Hampshire Water Transfer and Water Recycling Project

Environmental Statement – Appendix 5.3 Response to EIA Scoping Opinion

PLANNING INSPECTORATE SCHEME NUMBER: WA010002

May 2026

**Title**  
Figure 1.2  
Scoping Area  
Sheet 1 of 8

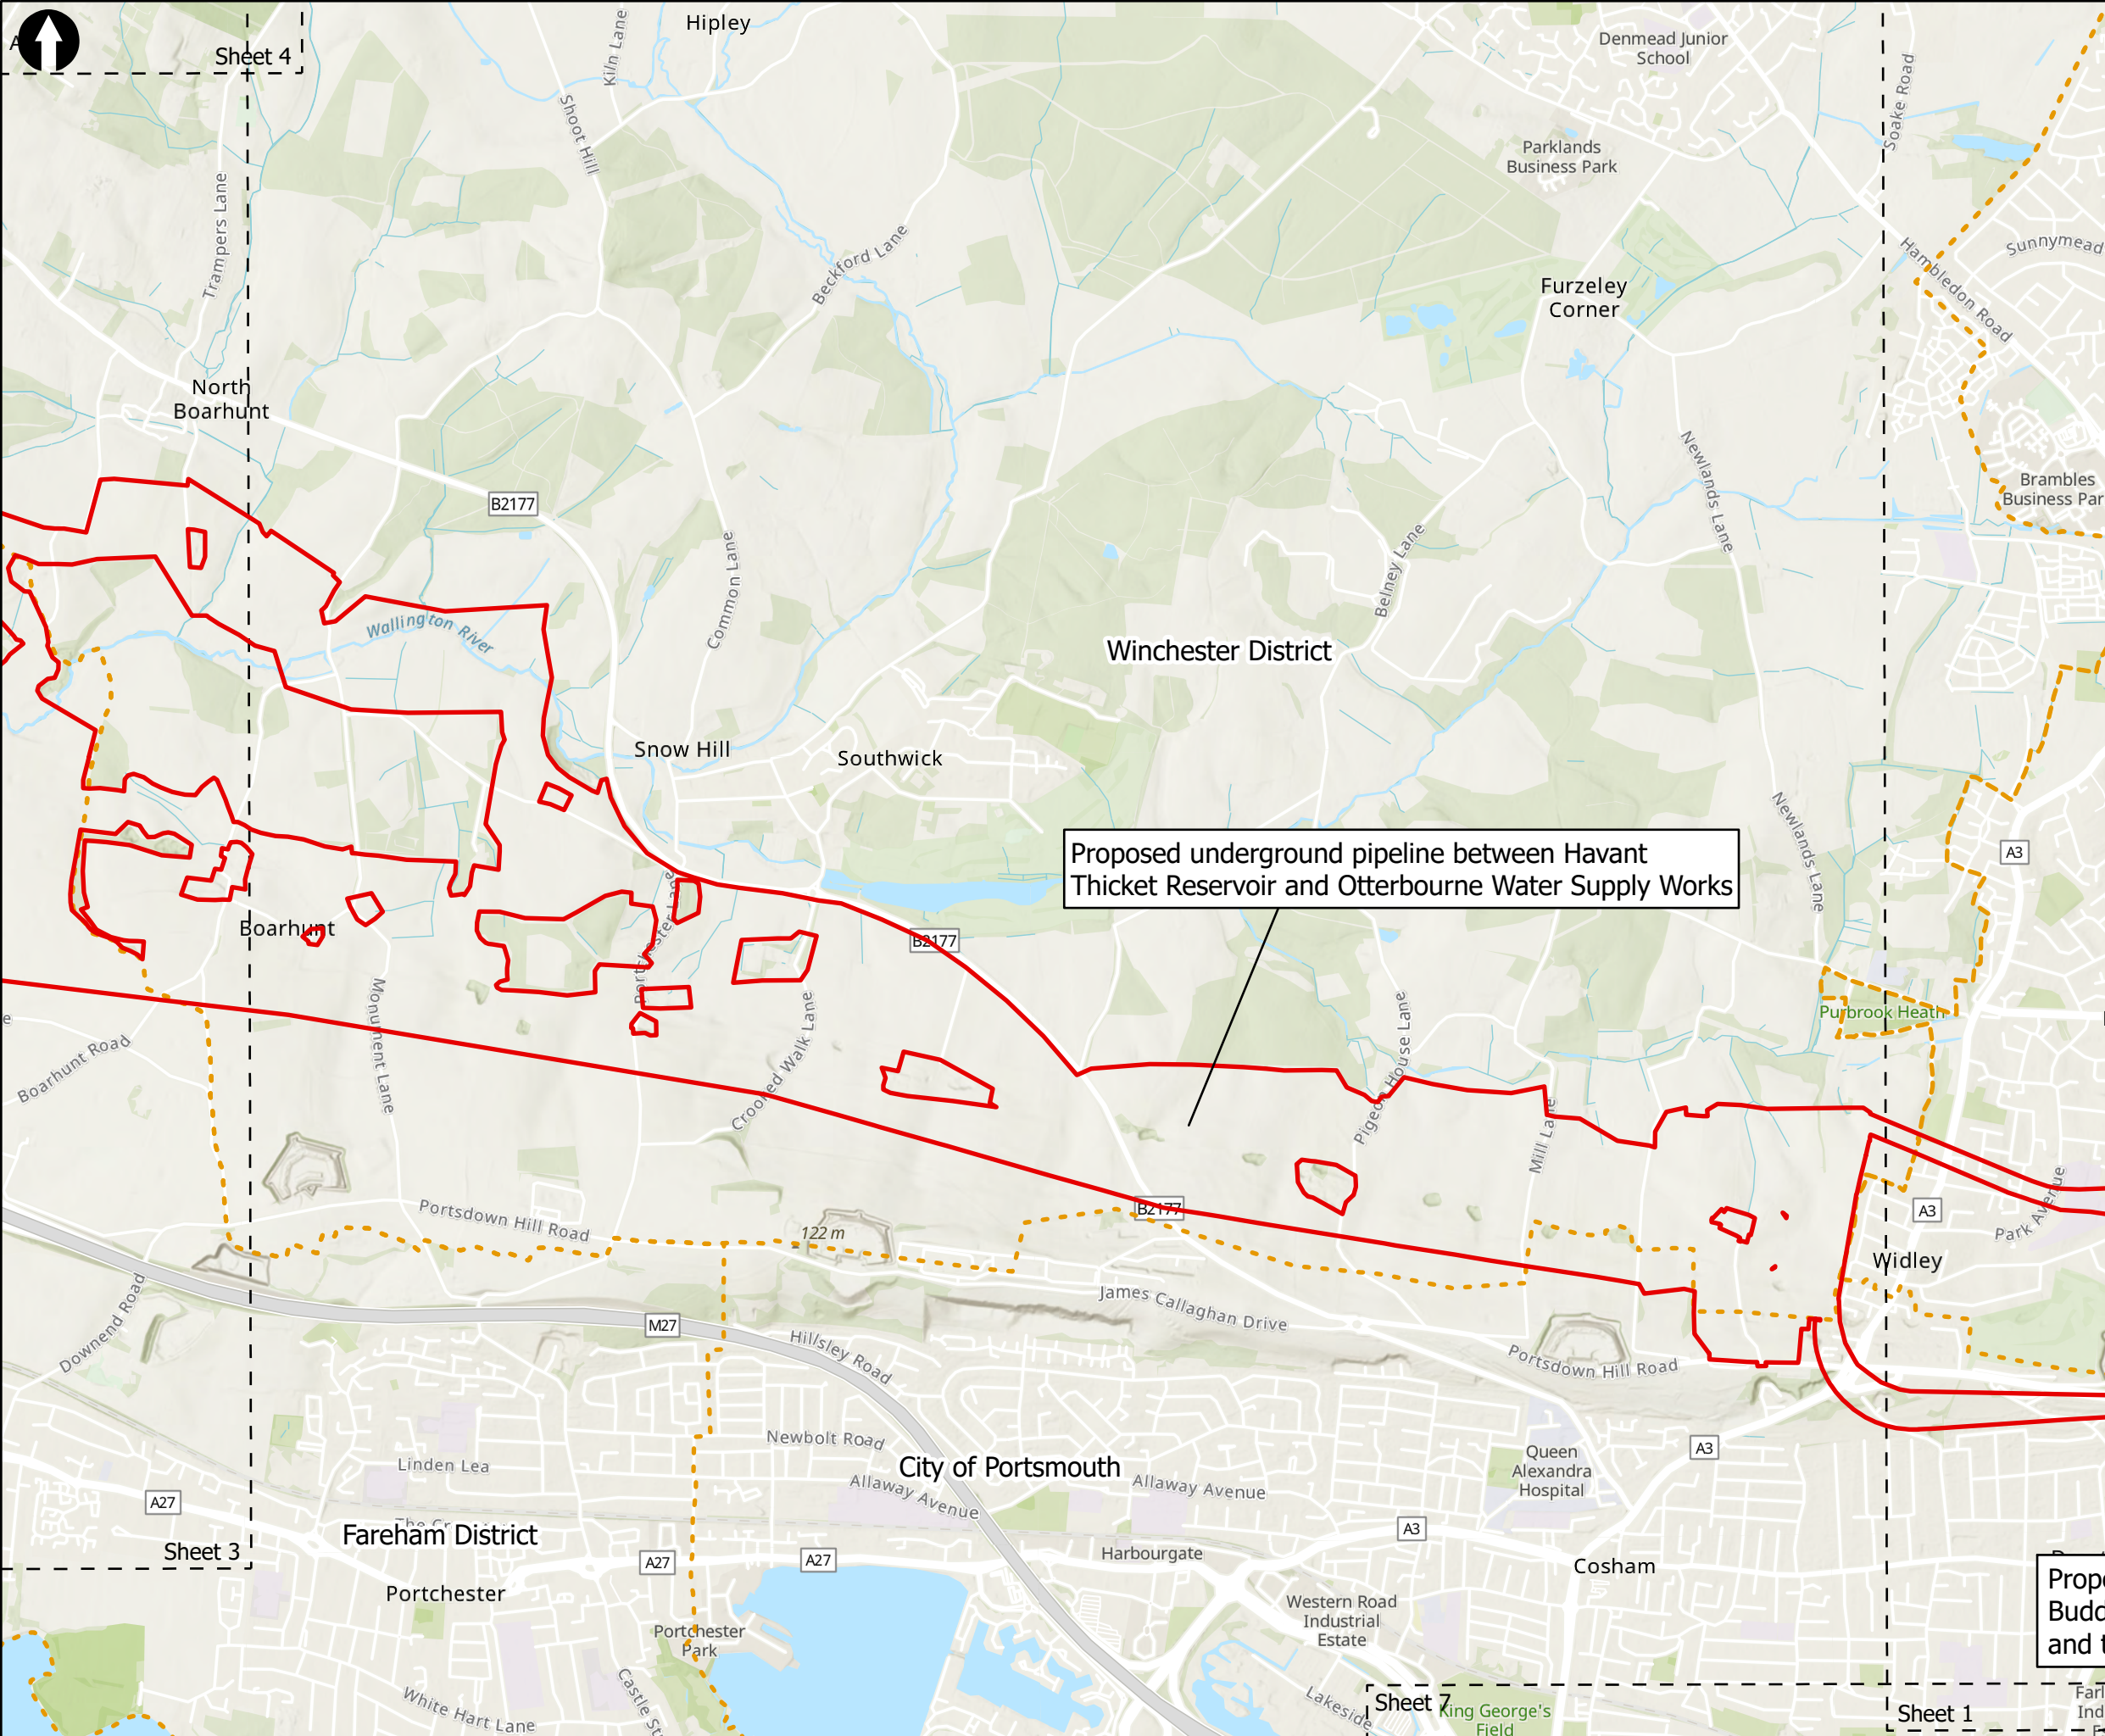
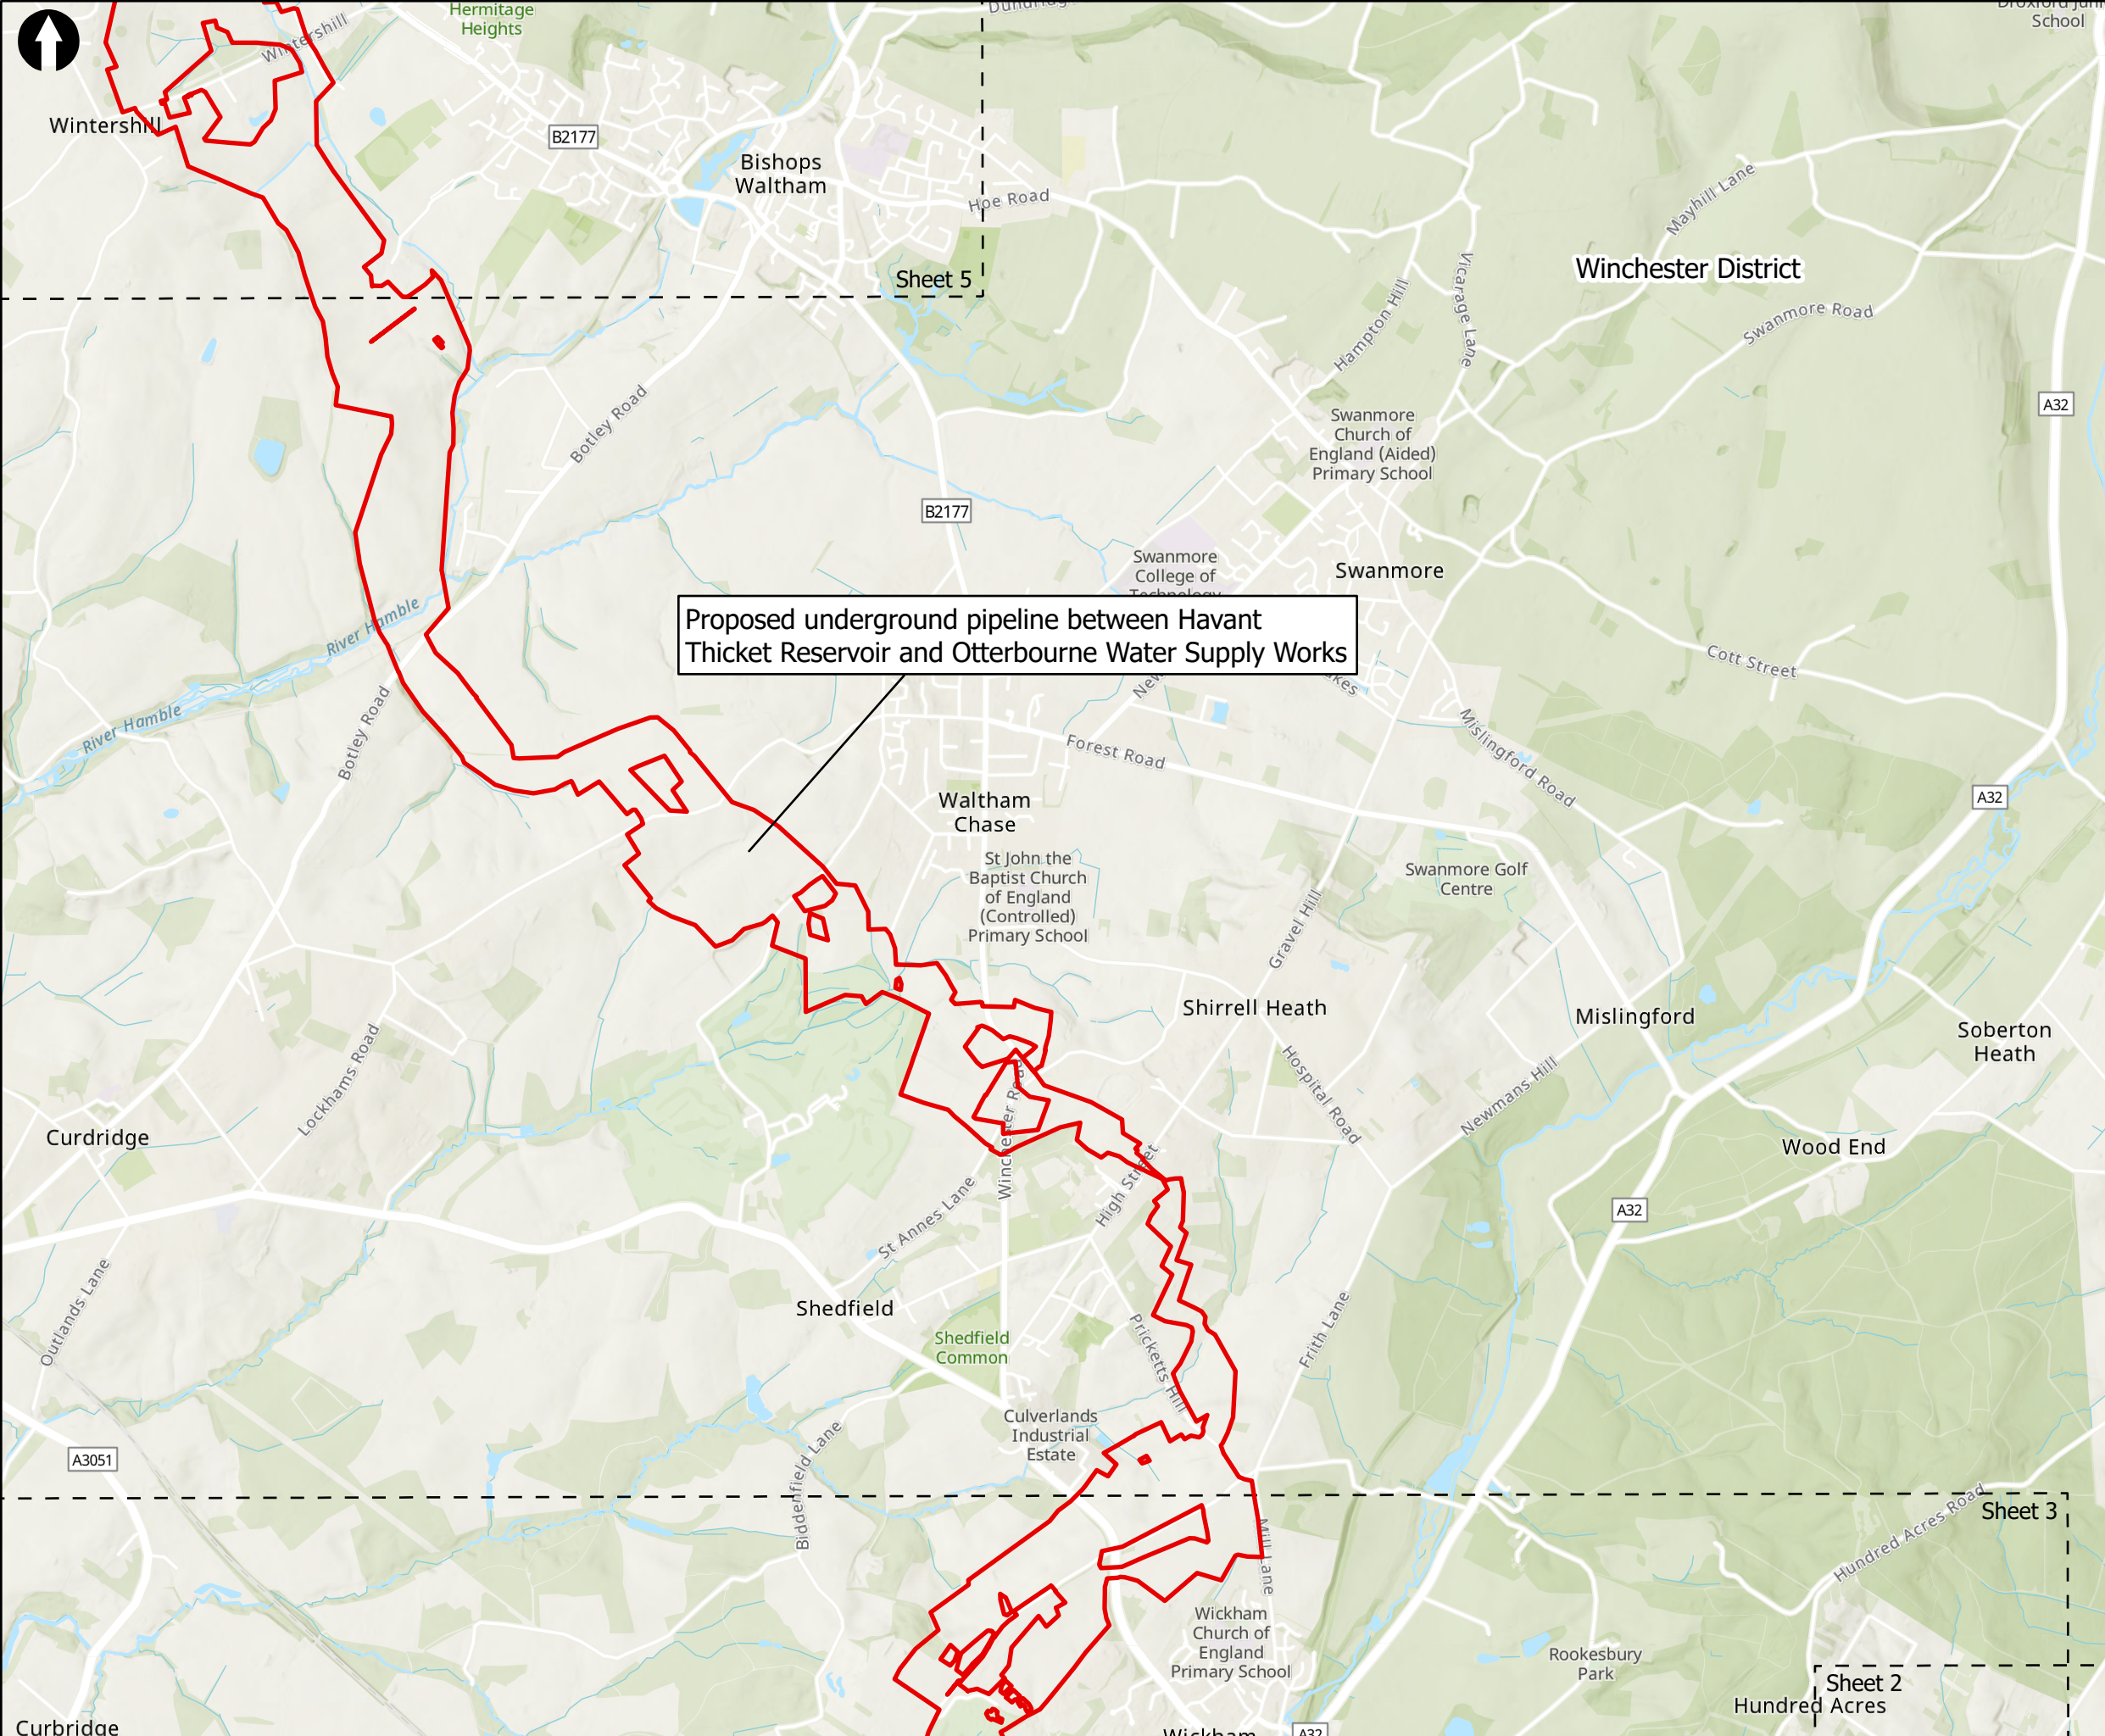
2.2.2	Chapter 4	<p>Order limits: <i>The scoping area shown on Figures 1.1 and 1.2 is proposed to be refined further through scheme development and EIA processes prior to confirmation of the Order limits within the DCO application. The ES should include an explanation of any changes made following scoping, including how environmental effects have been considered in finalising the Order limits.</i></p>	ES Chapter 4 Consideration of alternatives, Volume I (Document reference 6.1, DCO Volume 6), sets out how the Proposed Development has been refined following the EIA Scoping Opinion including how environmental effects, consultation and engagement have been considered. The DCO application includes a Scheme Development Report (Document reference 5.10, DCO Volume 5) which provides a detailed description of how the design of the Proposed Development been developed.
